**City of Portland, Maine – Building or Use Permit Application** 389 Congress Street, 04101, Tel: (207) 874-8703, FAX: 874-8716

Pre fab. single family home

Hobart St, Portland Maine 04103

197-K-1,2,19,20 cor. of Osgood

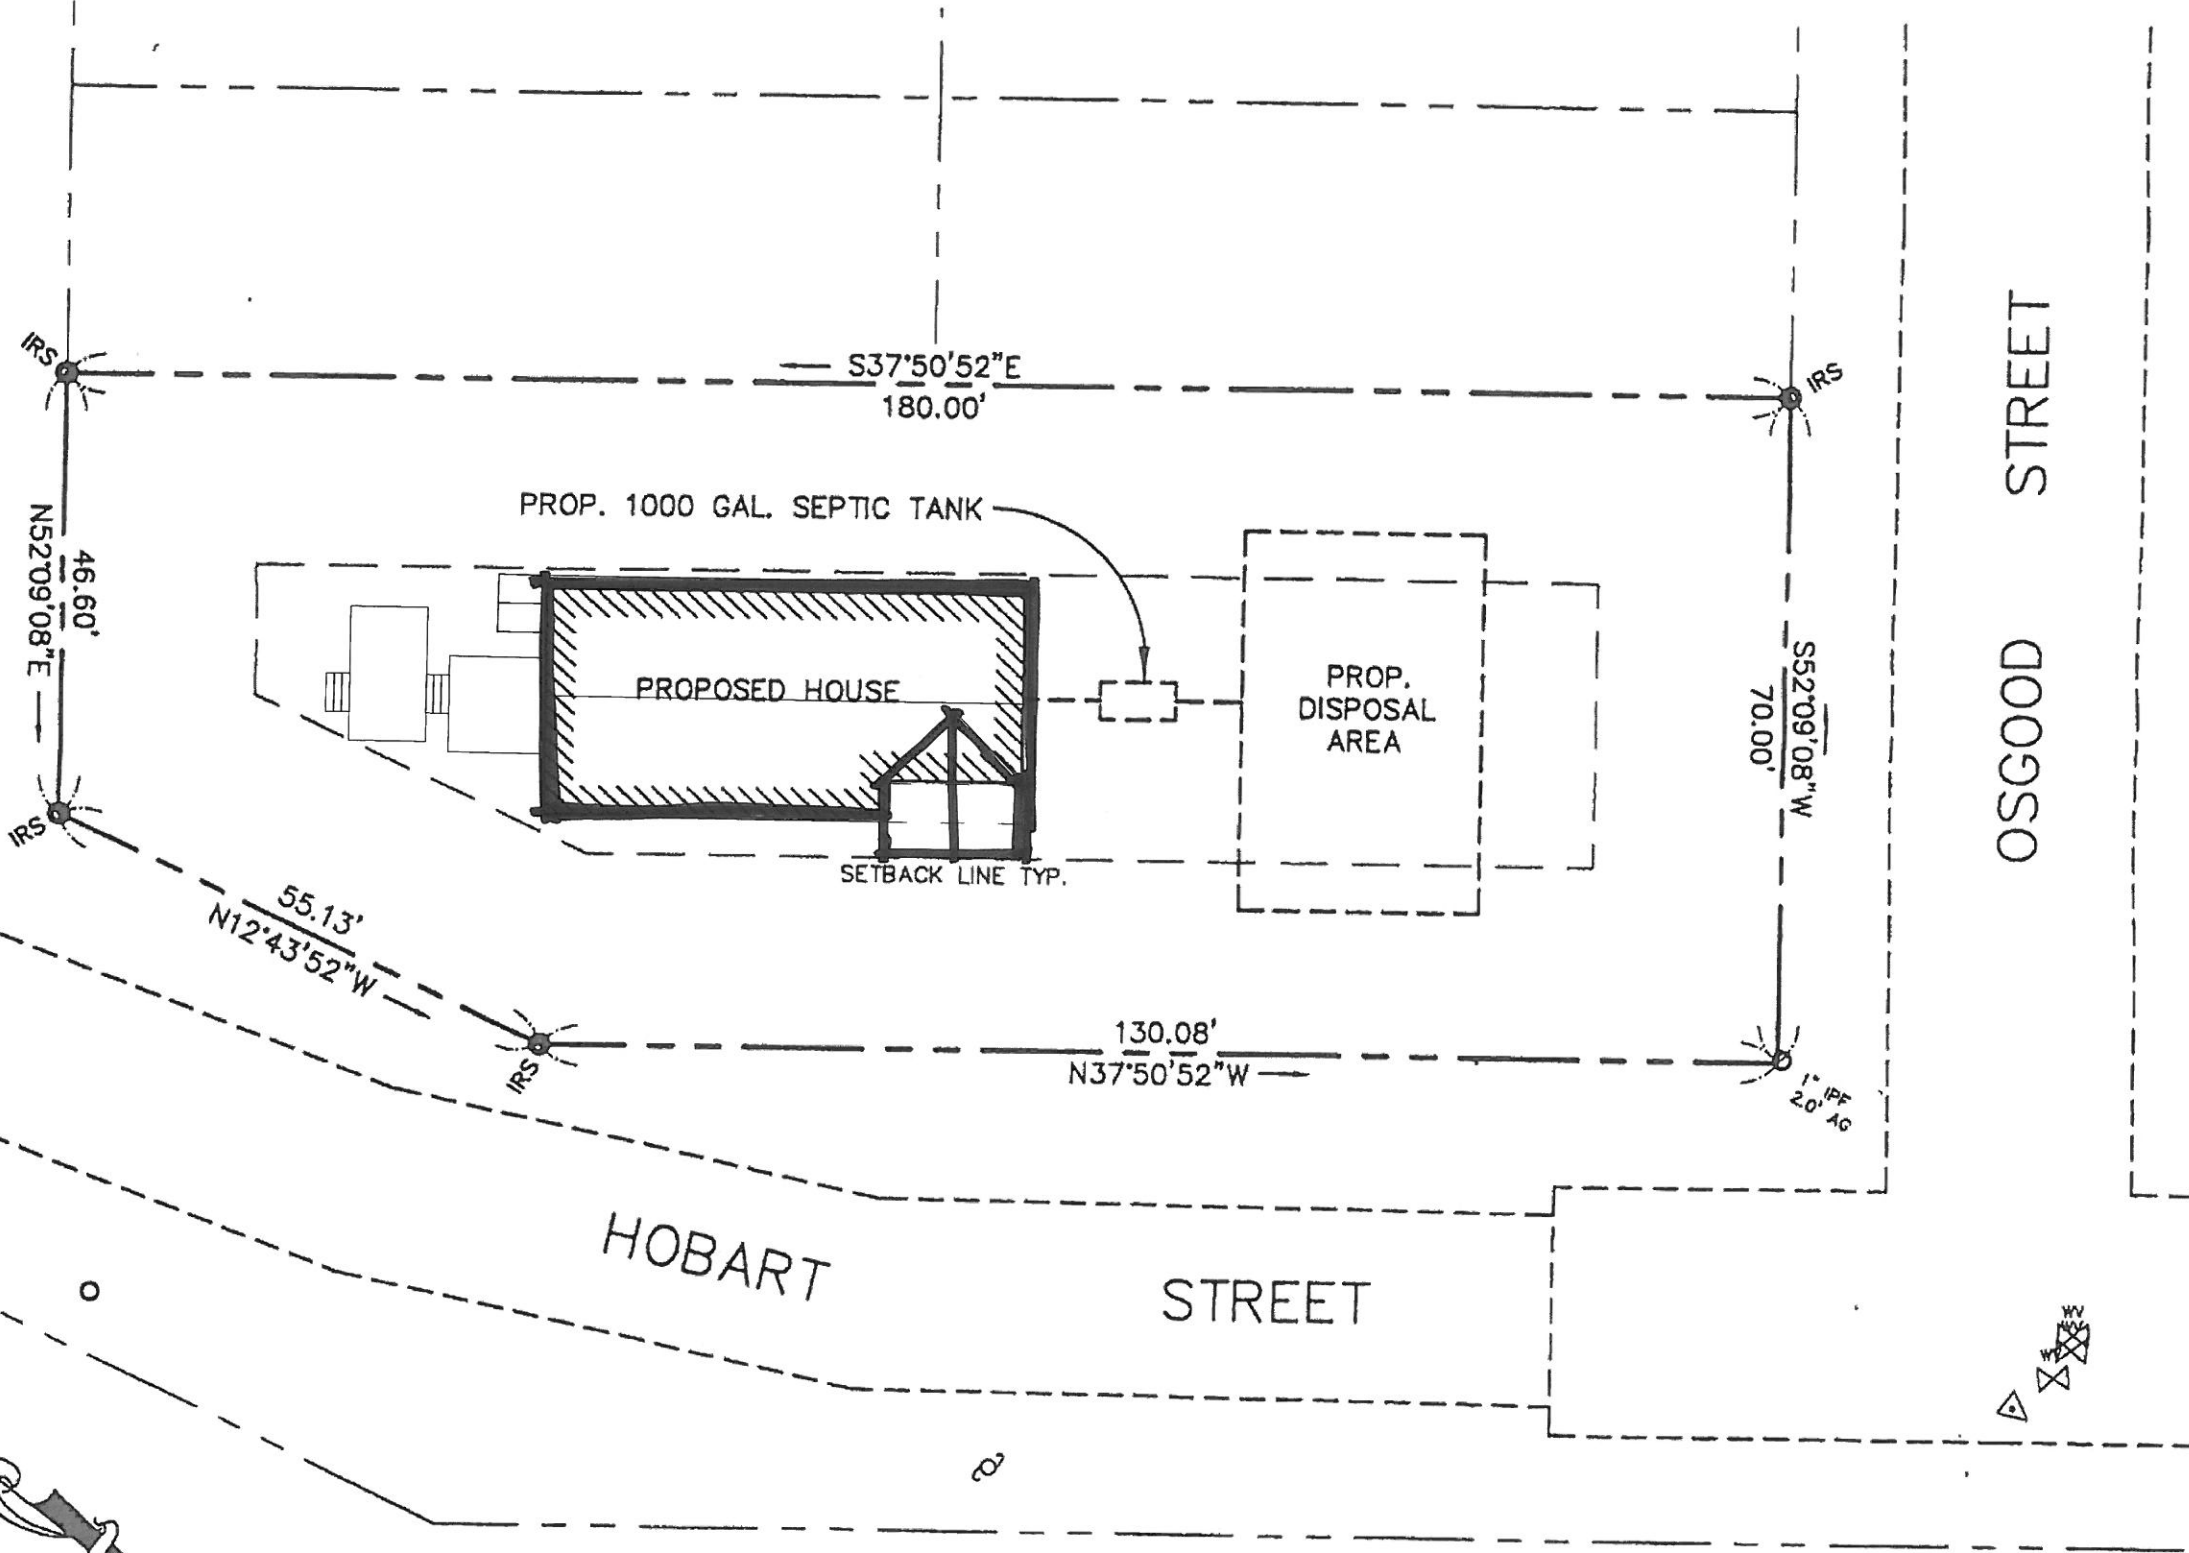
1. Plot plan does not show existing and proposed grade contours.

2. Stream limits and or wetlands exist on site and a permit may be required (NRPA). Permit is not issued by city, but my MDEP.

5. Utilities = water-sewer etc. shall be shown on the plot plan.

6. Specific surface restoration and stabilization of slopes shall be shown on the plot plan. (erosion control mesh-rip rap - or retaining walls, etc.)

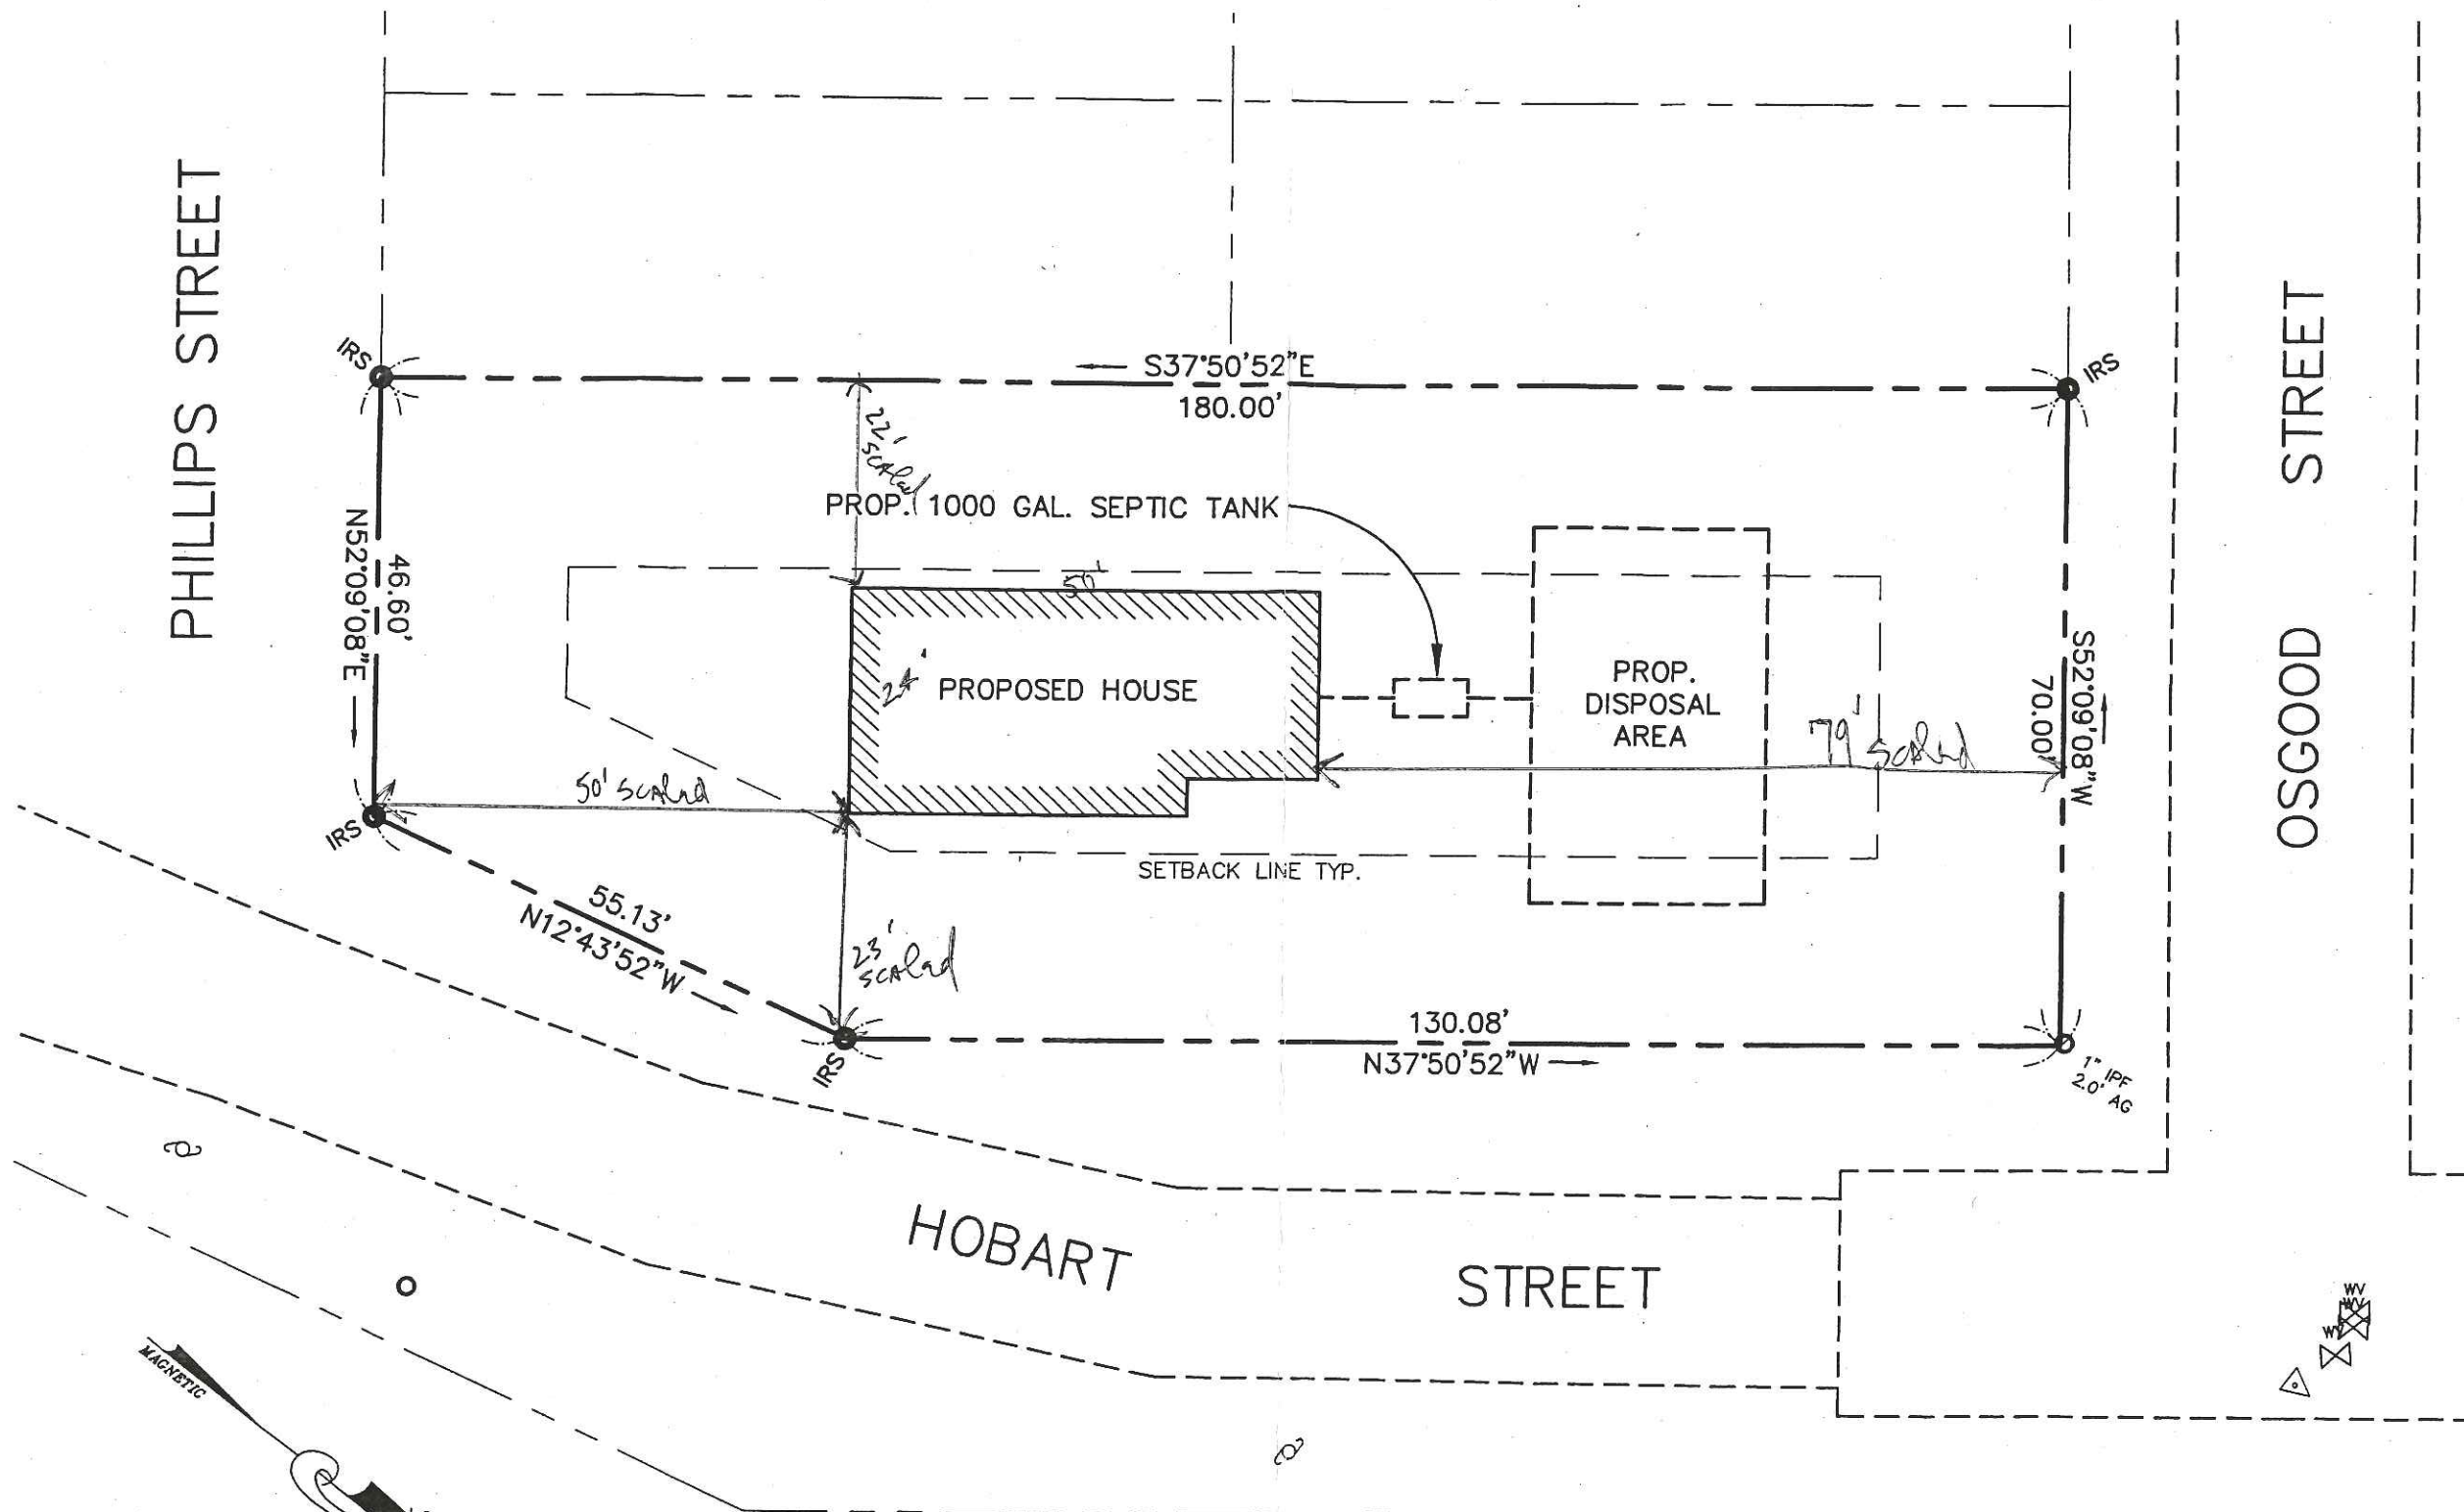
Applicant will be required to install additional silt fence, extending silt fence along the entire southwest property line.
